City of Albuquerque Stormwater Construction Site Inspection Report

ESC File No.	B18E029	Project Name:	The Peaks by Markana Ph 2		
NPDES Id. No.	NMR1004QW	Location:	6500 Glendale Avenue NE		
11/15/2023	Owner	Contractor			
Operator	KLA 9, LLC.	Kasam Construction			
Contact name & title	Faizel Kassam	Stephen Pendergraft			
e-mail	fkassam@legacy-hospitality.com	Spendergraft@Legacydm.net			
Contact Phone #	505-489-4474	720-7188			
COA Inspector	Doug Hughes	Start/End Time:	10:30am		
Construction Phase:	Staging				
Type of Inspection:	Regular	Storm Event	Past Storm Event >0.25"	311/Complaint	Follow Up
Weather at time of inspection?		Cloudy	Temperature:	~	55
Estimated date of last storm 0.25" or greater		8/8/2023

TEMPORARY EROSION AND SEDIMENT CONTROL PLAN

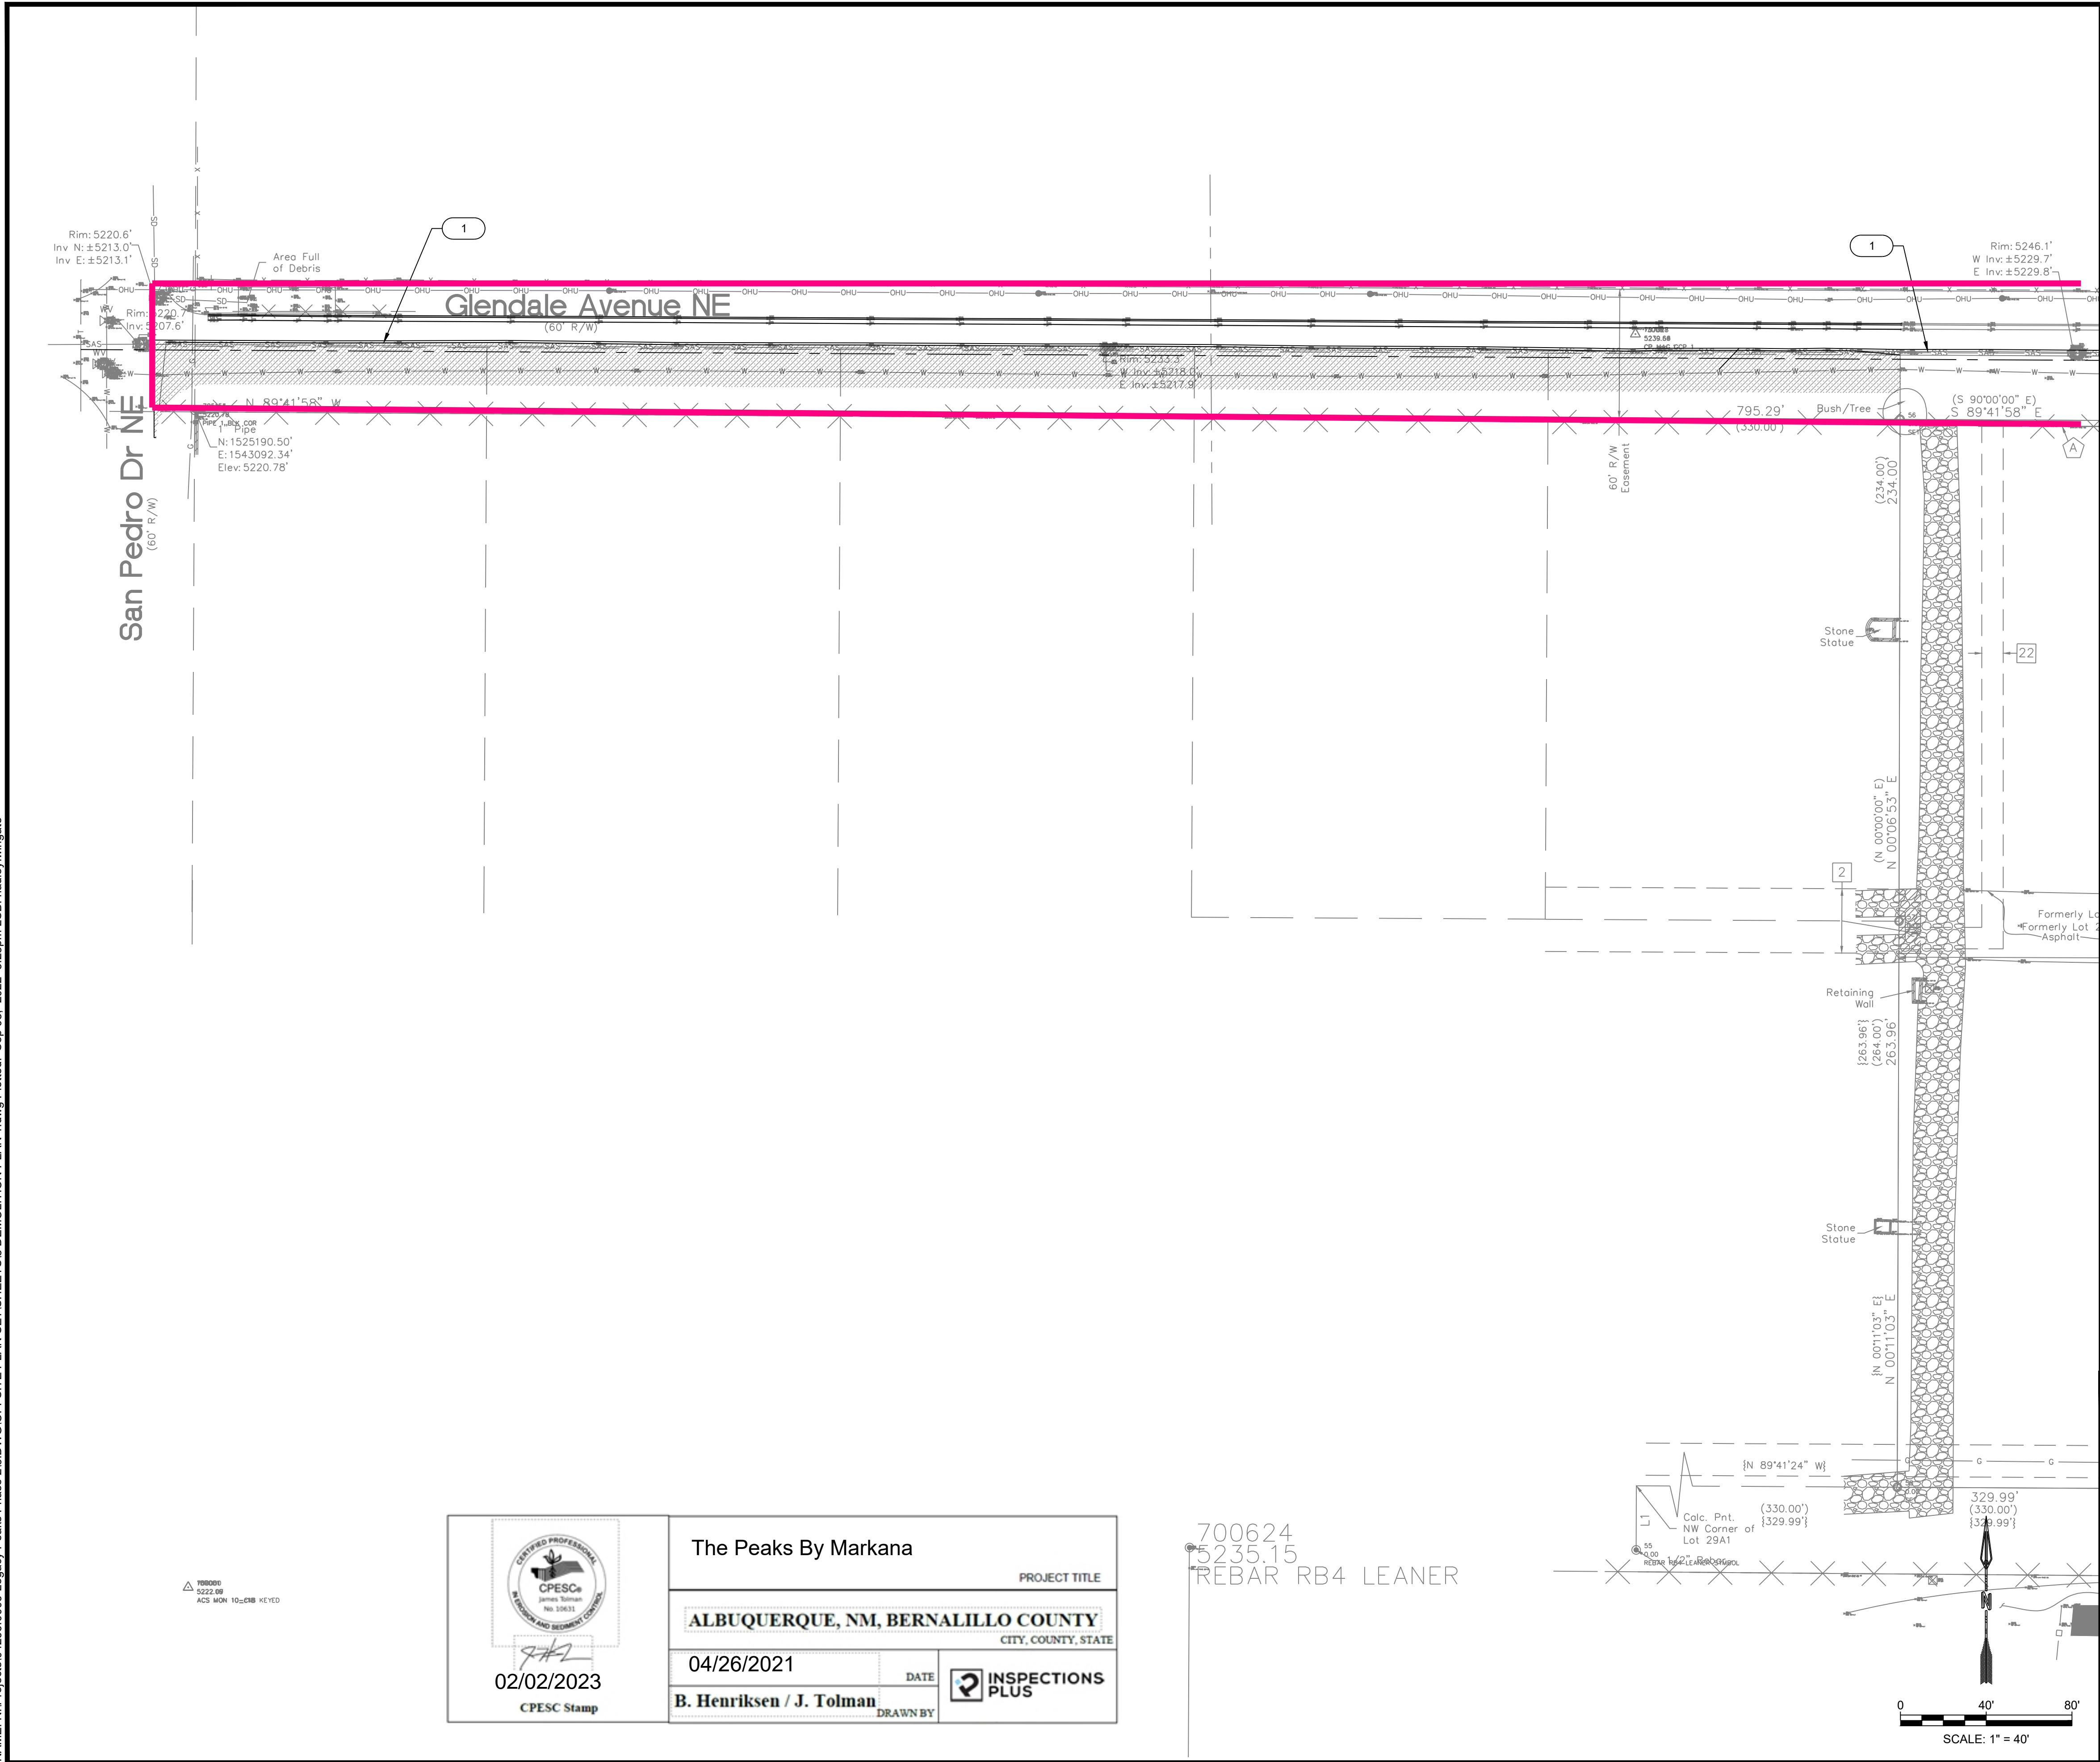
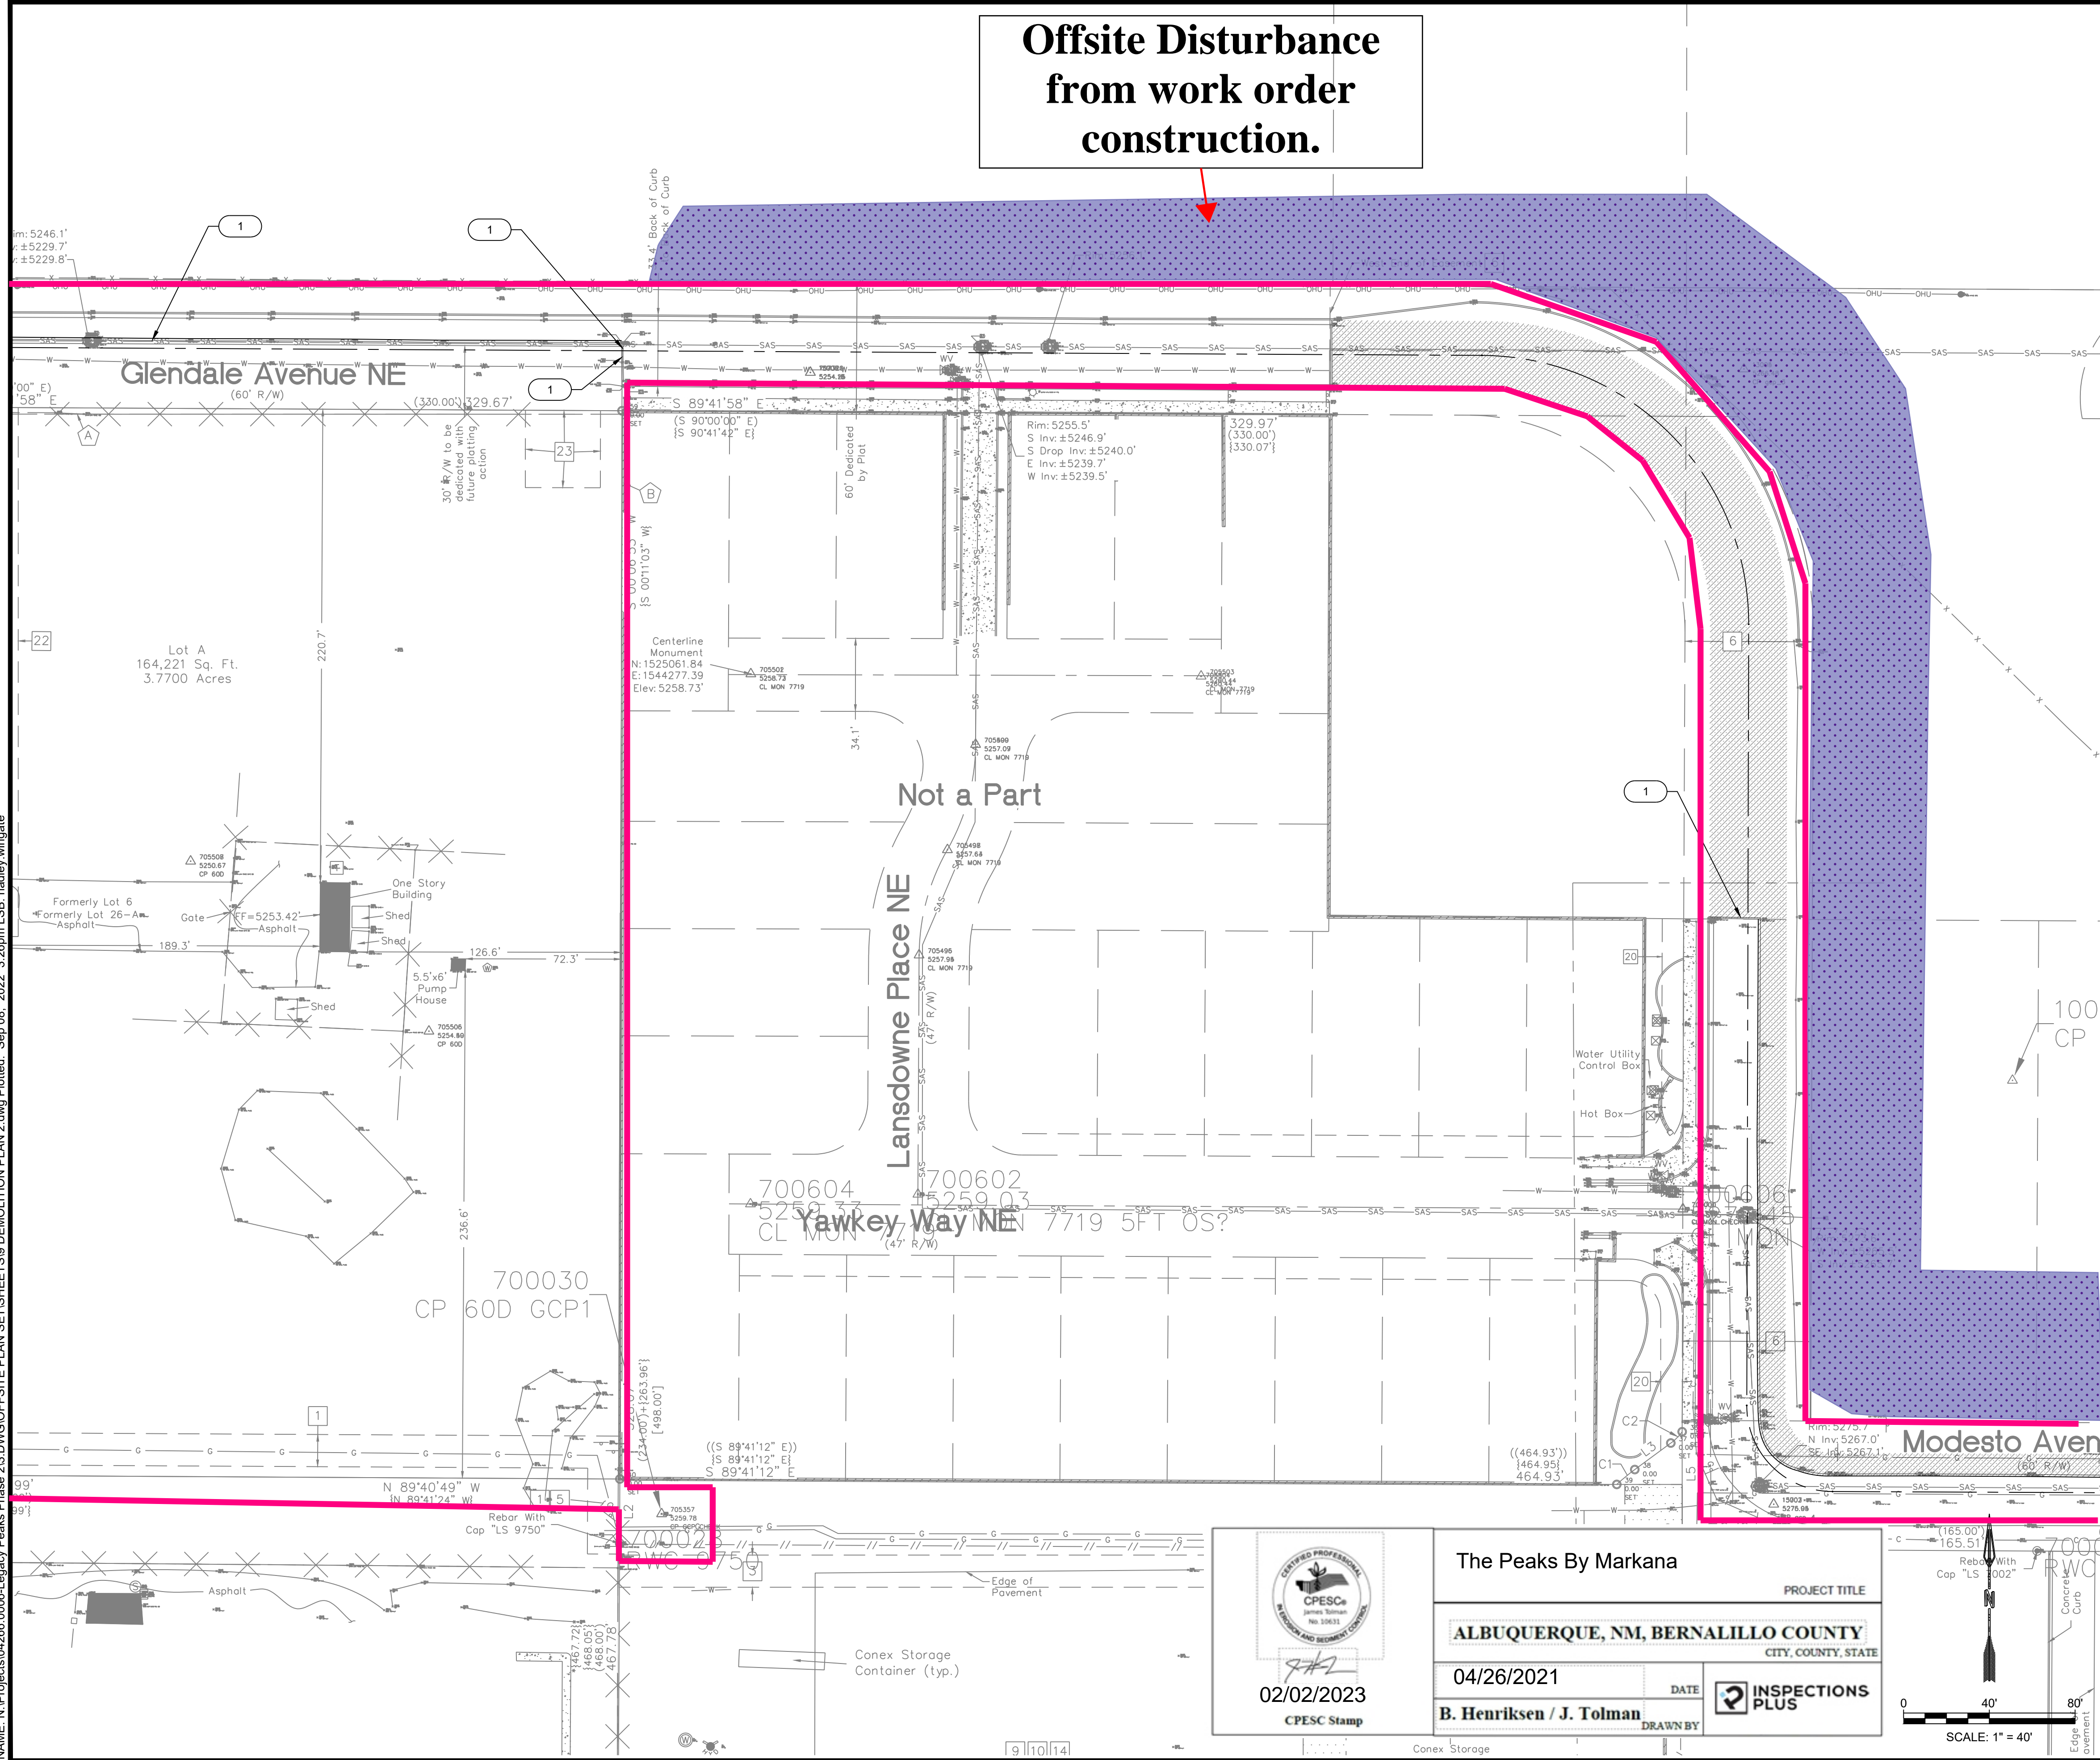
Item Number	Deficiency/ Corrective Action				
1	SWPPP - The offsite areas were added to the SWPPP map, but specifications for perimeter controls and stabilization were still missing on the offsite 40' to 50' wide strip of land disturbing activities located north of Modesto Ave and east of Glendale Ave on the Pueblo of Sandia's property in violation of CGP 2.2.3 and CGP 2.2.14 respectively. Self-inspections were not performed during the 497 days from 6/29/22 to 11/8/23. At least 35 inspections were missed at a rate of one inspection every two weeks, not counting any missed rain event inspections. Required Mitigation: Add controls to the SWPPP map.				
2	BMPs - Perimeter controls and stabilization are still missing on the offsite 40' to 50' wide strip of land disturbing activities located north of Modesto Ave and east of Glendale Ave on the Pueblo of Sandia's property in violation of CGP 2.2.3 and CGP 2.2.14 respectively. Construction Exits(CE) had been reset onsite, but they didn't extend through the ROW to the paved city street. Required Mitigation: Add the missing BMPs.
